Recommendation Report for Planning Permission

REF NO: LU/30/14/

LOCATION: Waterfront
46 Pier Road
Littlehampton West Sussex

PROPOSAL: Change of use of part of first floor from flat to restaurant. Single storey extension and roof re-modelling to rear - resubmission of LU/350/13

Drawing:
Proposed floor plan

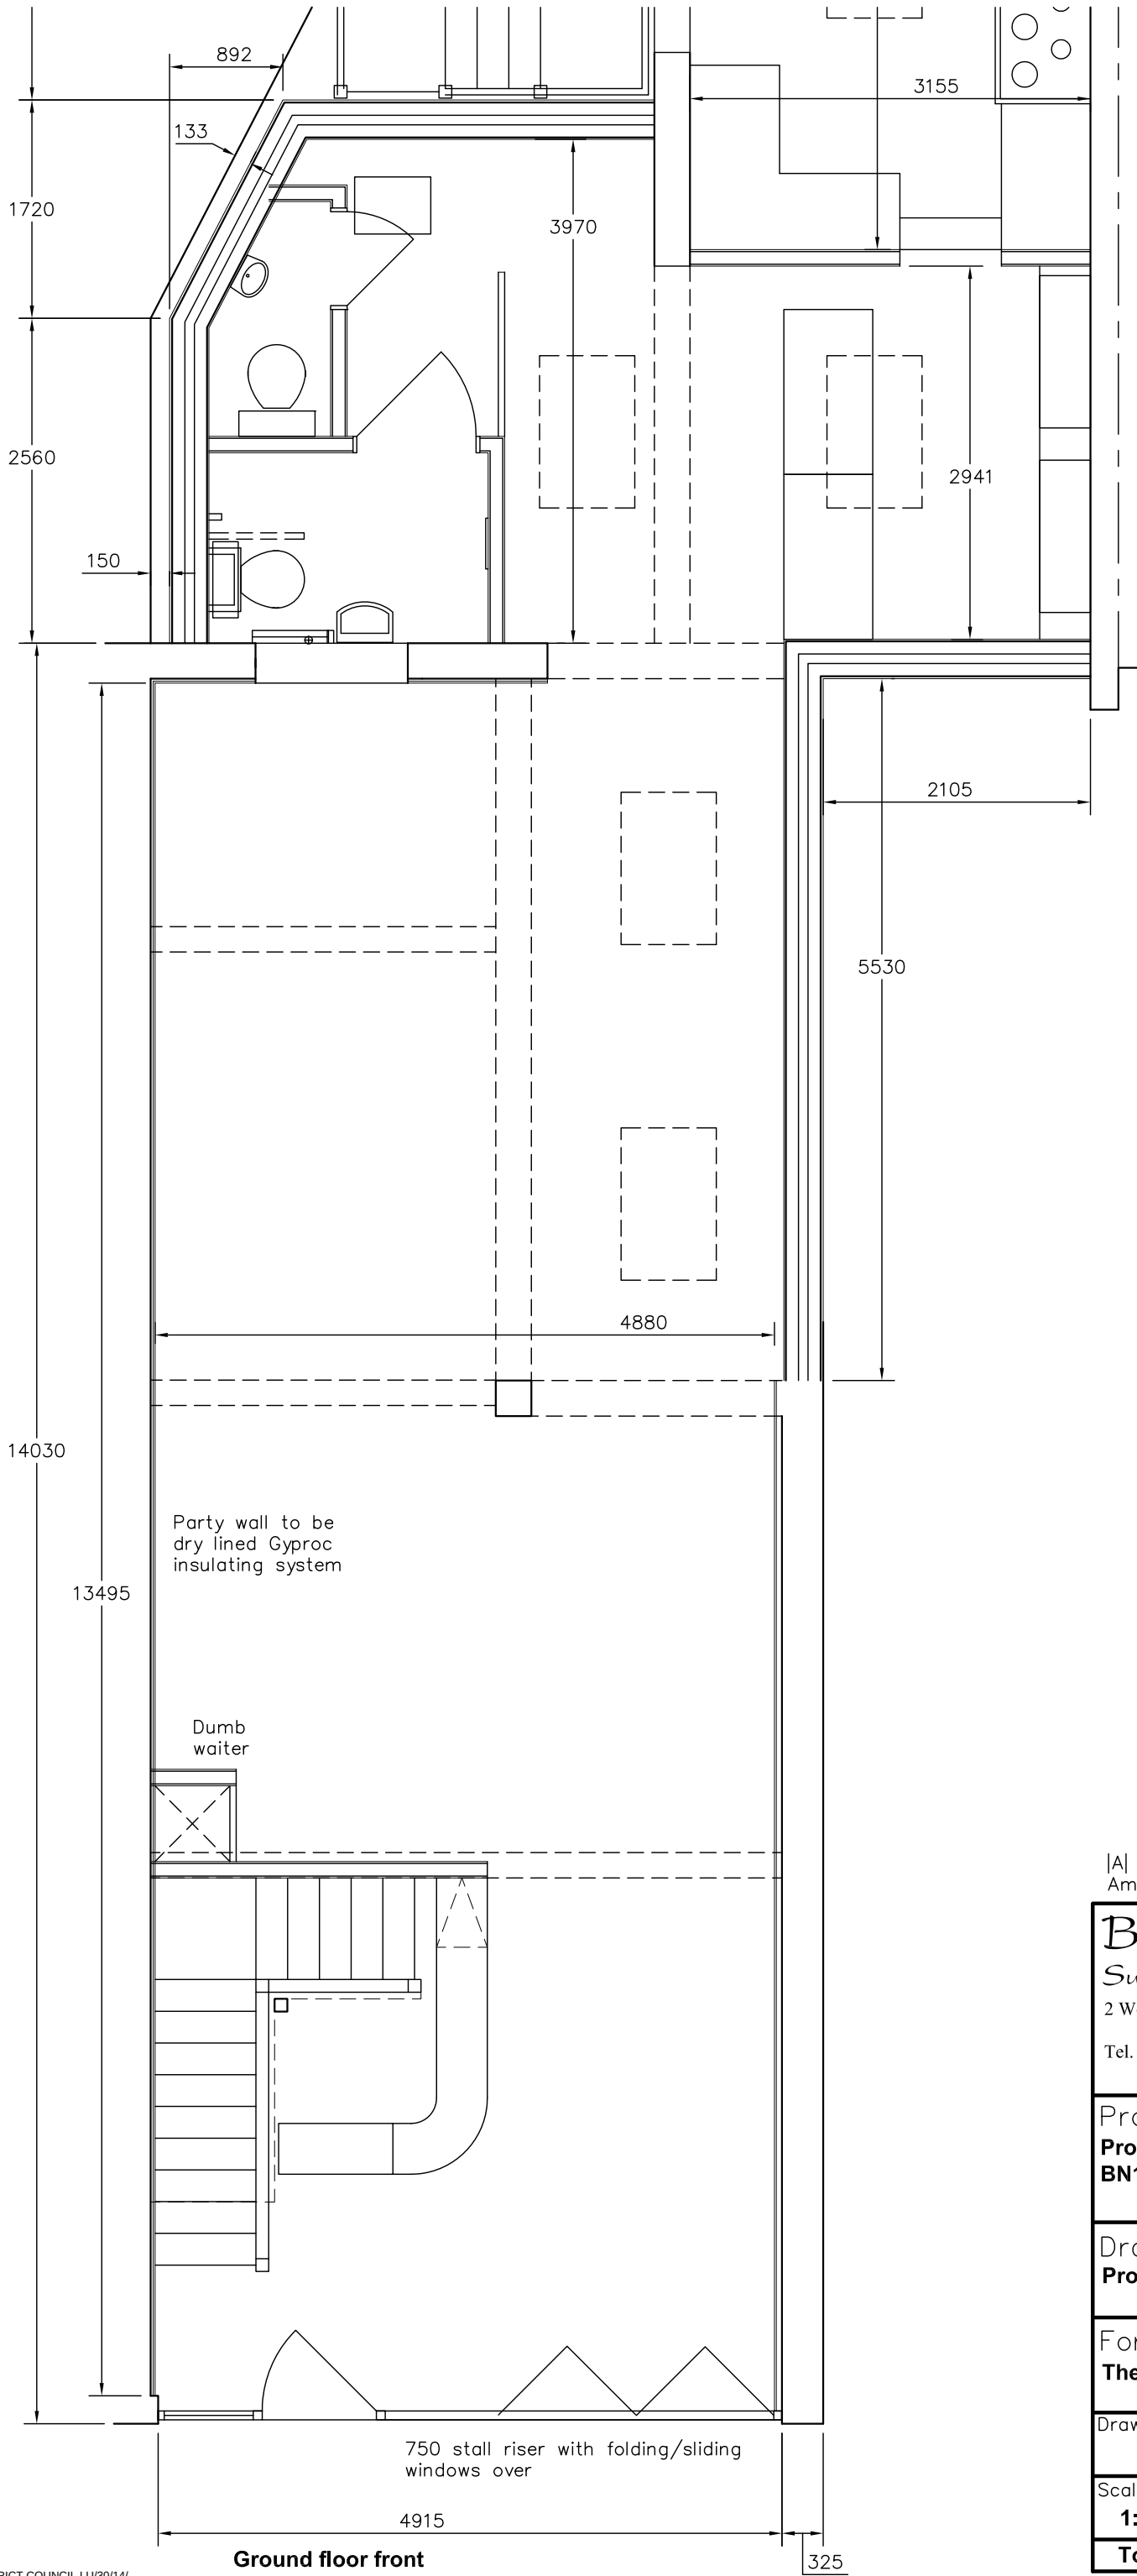
Staircase and dumb waiter would be adjacent to party wall. Concern regarding associated noise permeating living room and hallway.

Since the previous withdrawal the internal and external space standards in the Emerging Local Plan are being applied. The kitchen and lounge dimensions do not accord with the minimum floor area requirements and this together with the lack of adequate external space means the proposal is therefore contrary to policies DDM1 and DDM2 of

Drawing:
Floor and roof plans

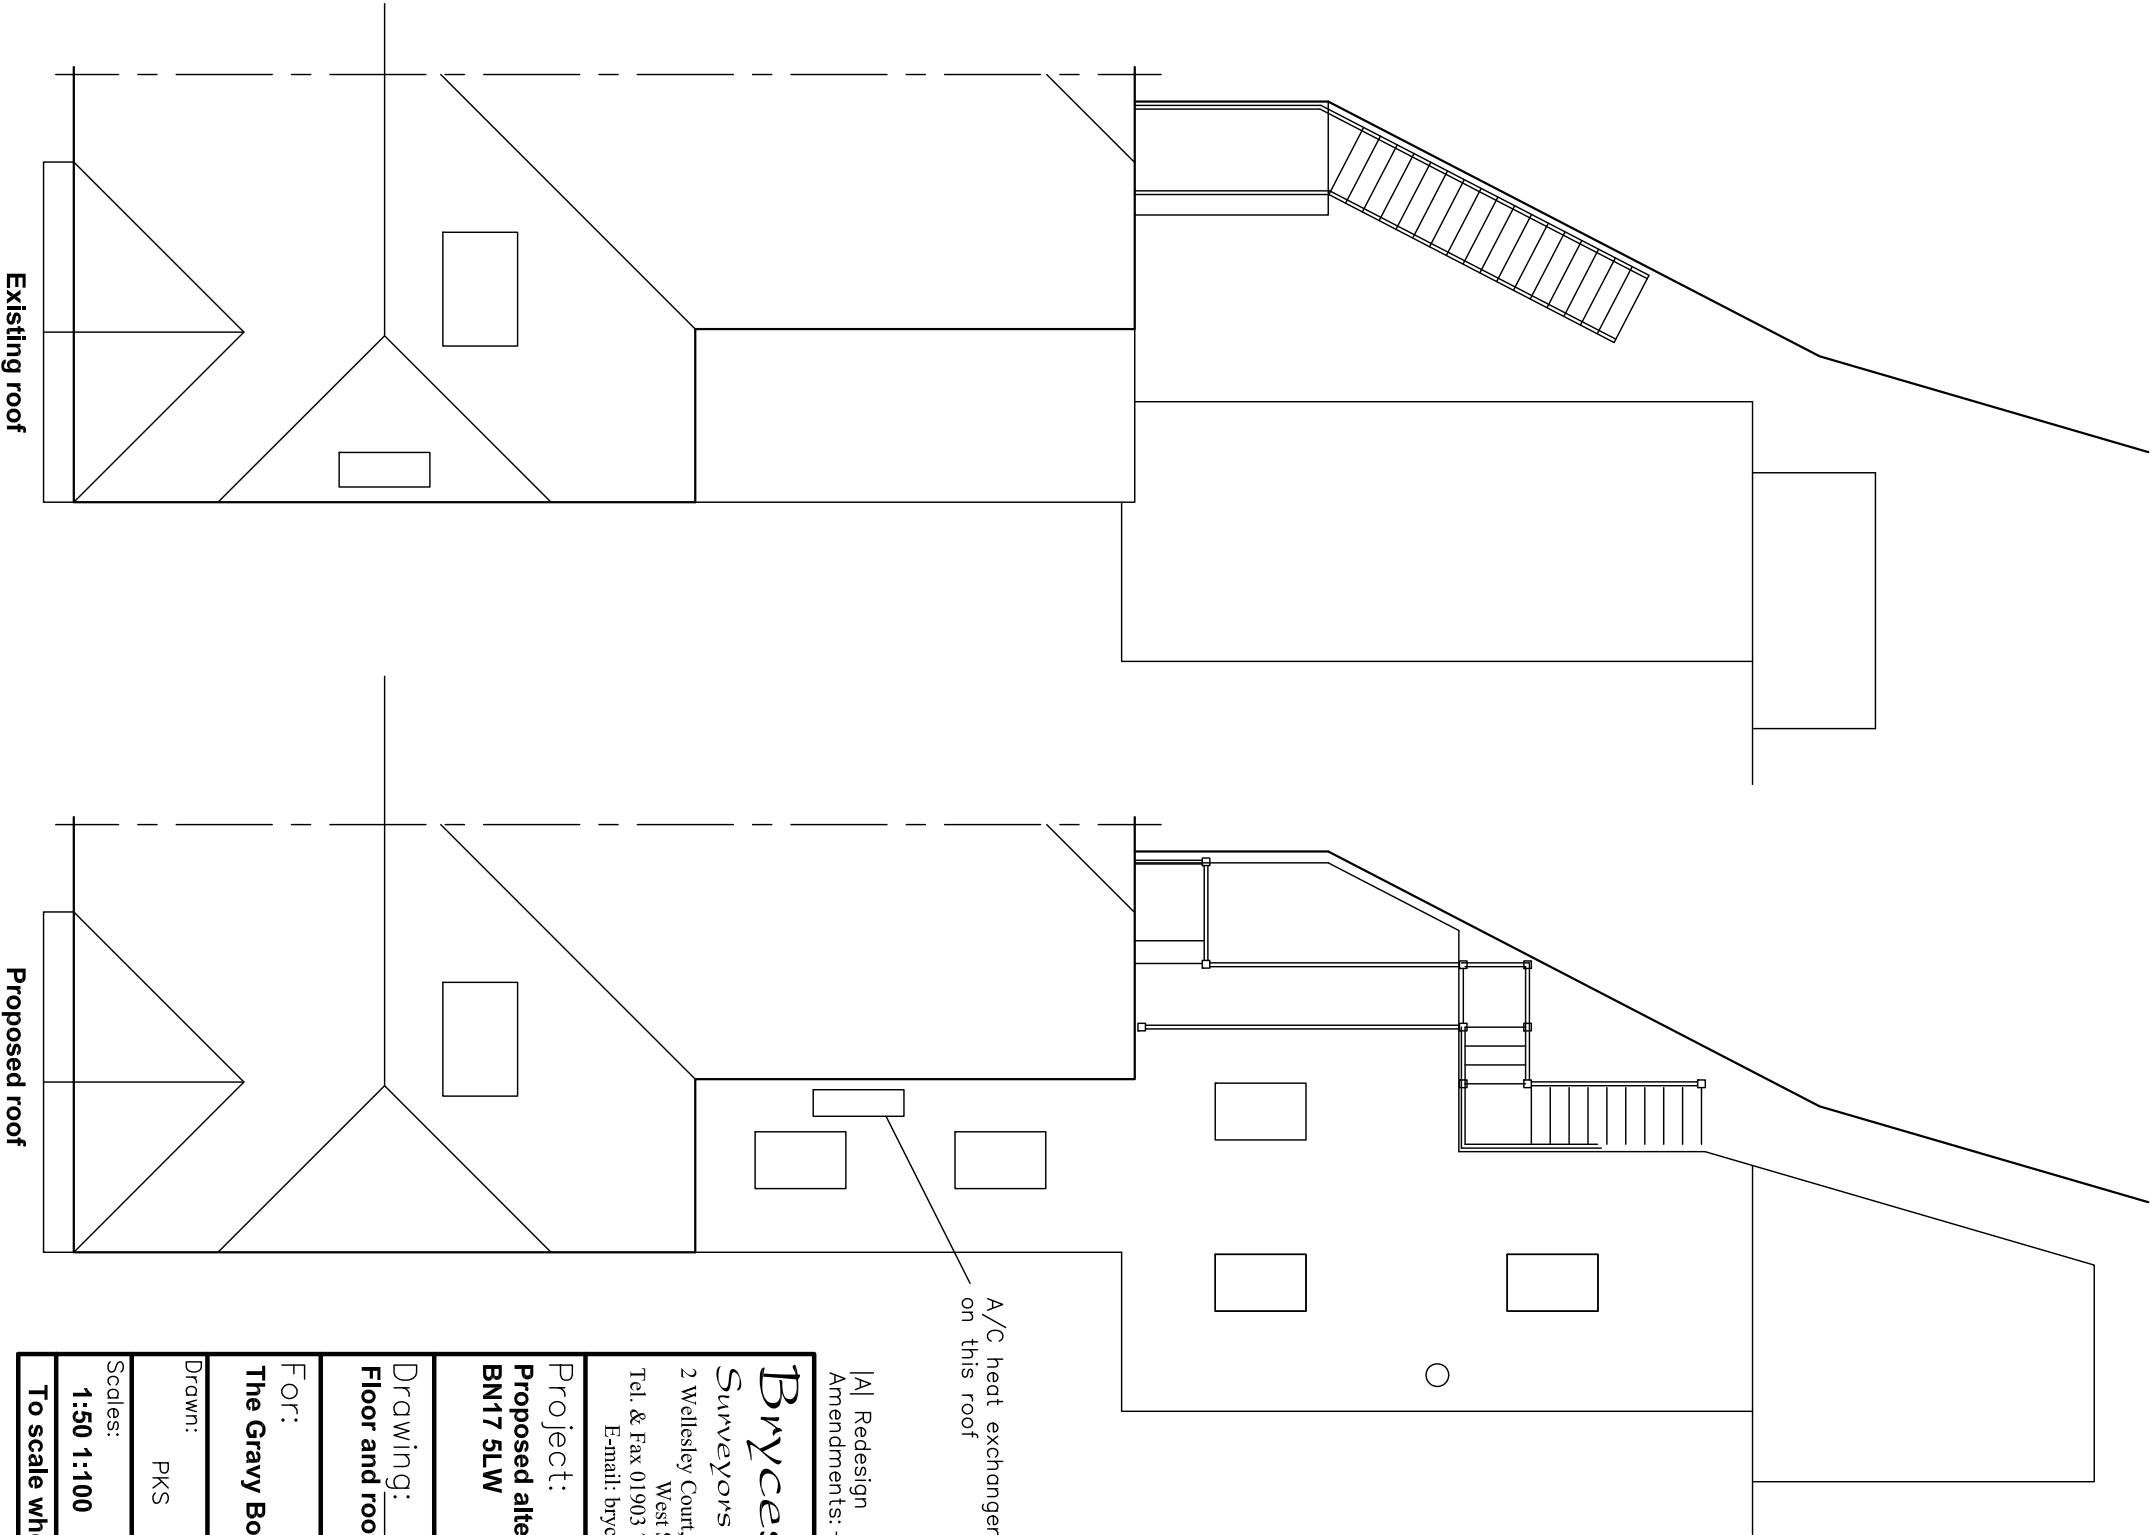
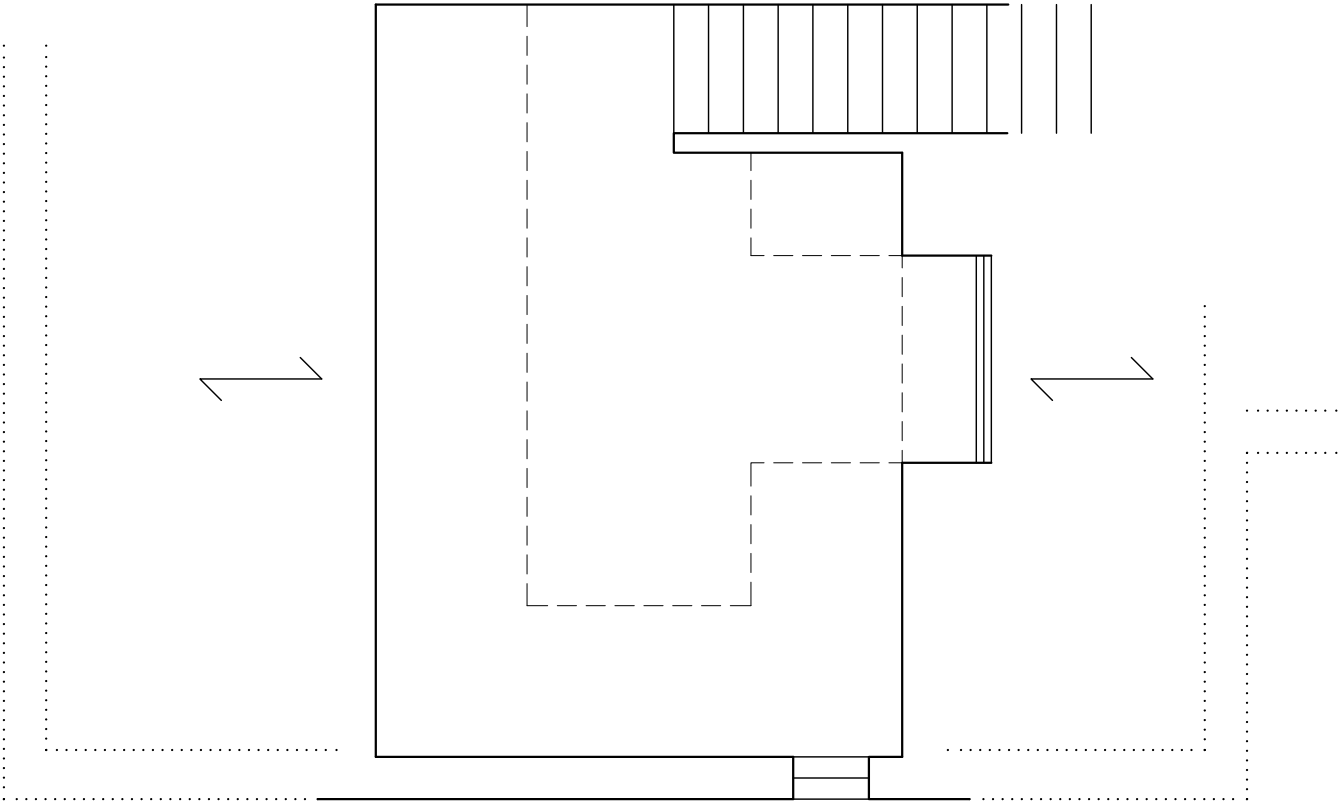
The application also indicates proposed compressor/air handling unit. No information is provided in respect of potential impact of noise on nearby neighbours. In particular hours of use, noise power/sound levels and distance to sensitive receptors.

However the lack of information in respect of the proposed noise generation from equipment,

sound levels in relation to distance to sensitive receptors and provision of an appropriate extract ventilation system result in development that has not been proved to have an acceptable impact on the residential amenities of adjoining residential properties. The proposal is therefore contrary to policies GEN7, GEN32 and DEV26 of Arun District Local Plan and policies DDM1, QEDM1 and RETDM1 of the Emerging Local Plan.
